# CITY OF ALBUQUERQUE

**RE: Mesa Del Sol Neighborhood - Montage Units 3 & 4  
Drainage Report for Preliminary Plat Approval and Grading Permit  
Engineer's Stamp Date 4-25-2014 (File: R16D006)**

Based upon the information provided in your submittal received 4-25-14, the above referenced Drainage Report cannot be approved for Preliminary Plat Approval by the DRB or Grading Permit until the following comments are addressed:

EXISTING CONDITIONS BASIN MAP

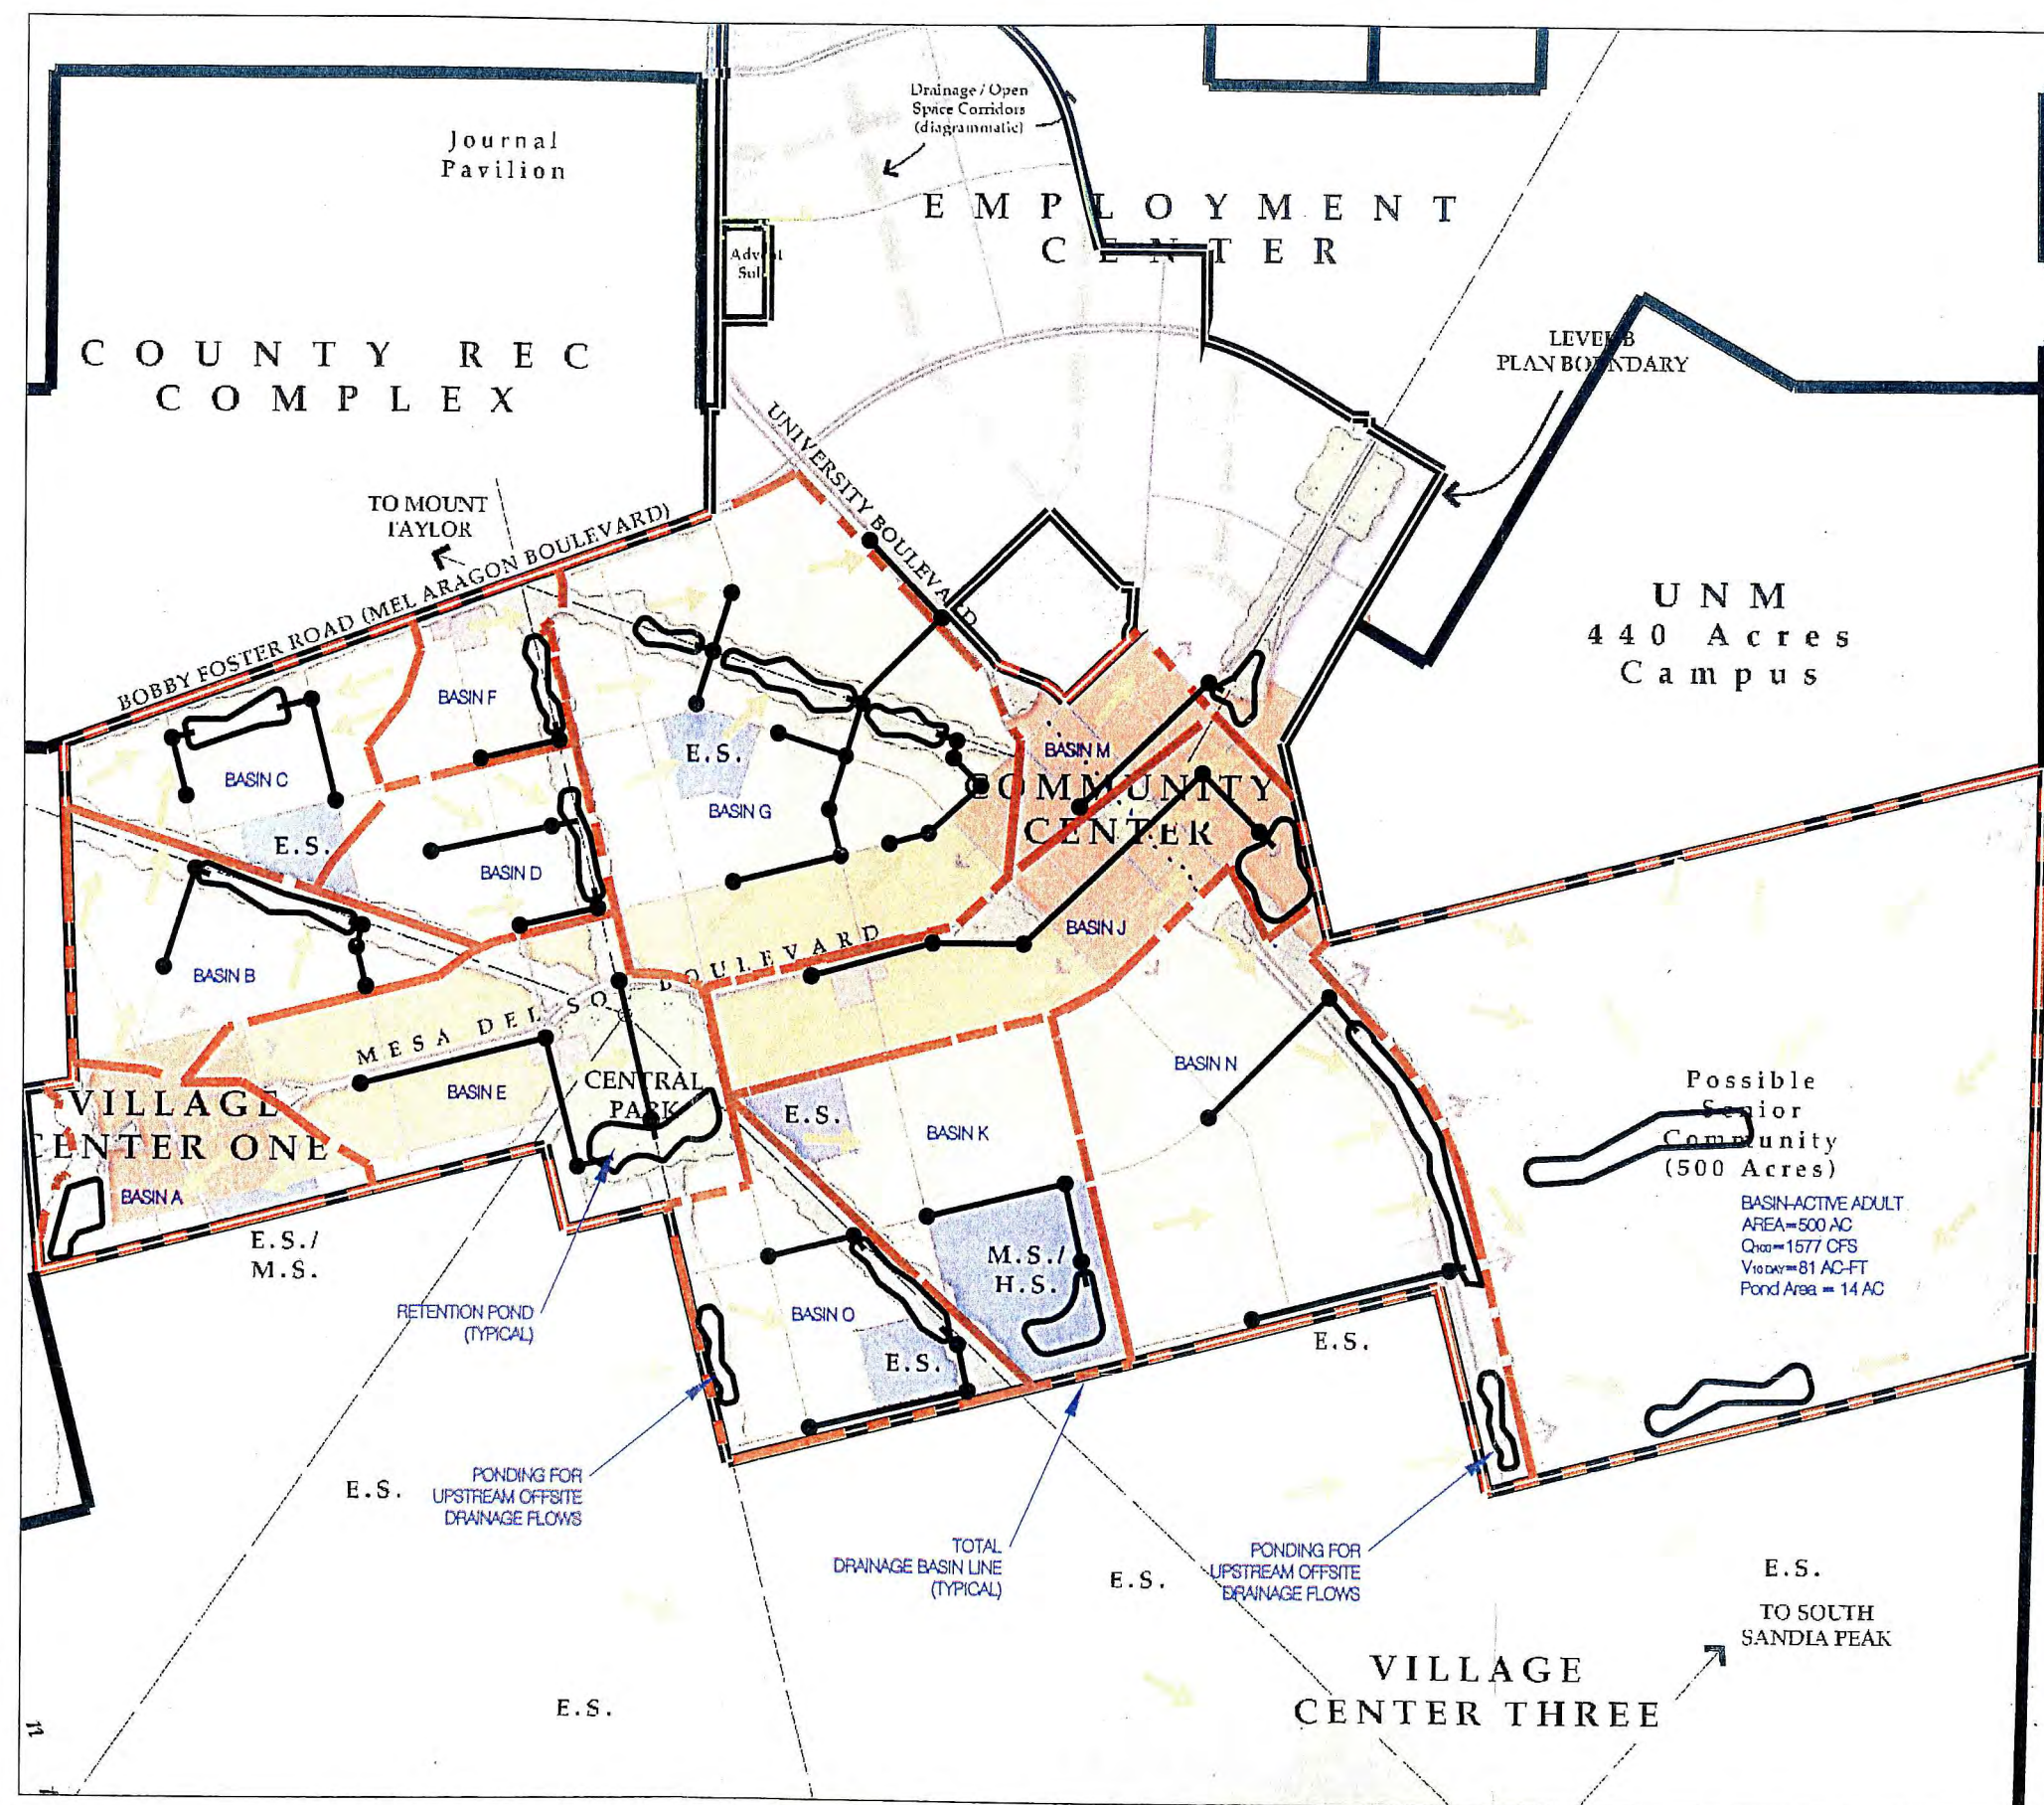
7. Basin M in the Existing Conditions Basin Map is not fully accounted for in the Proposed Condition Basin Map.
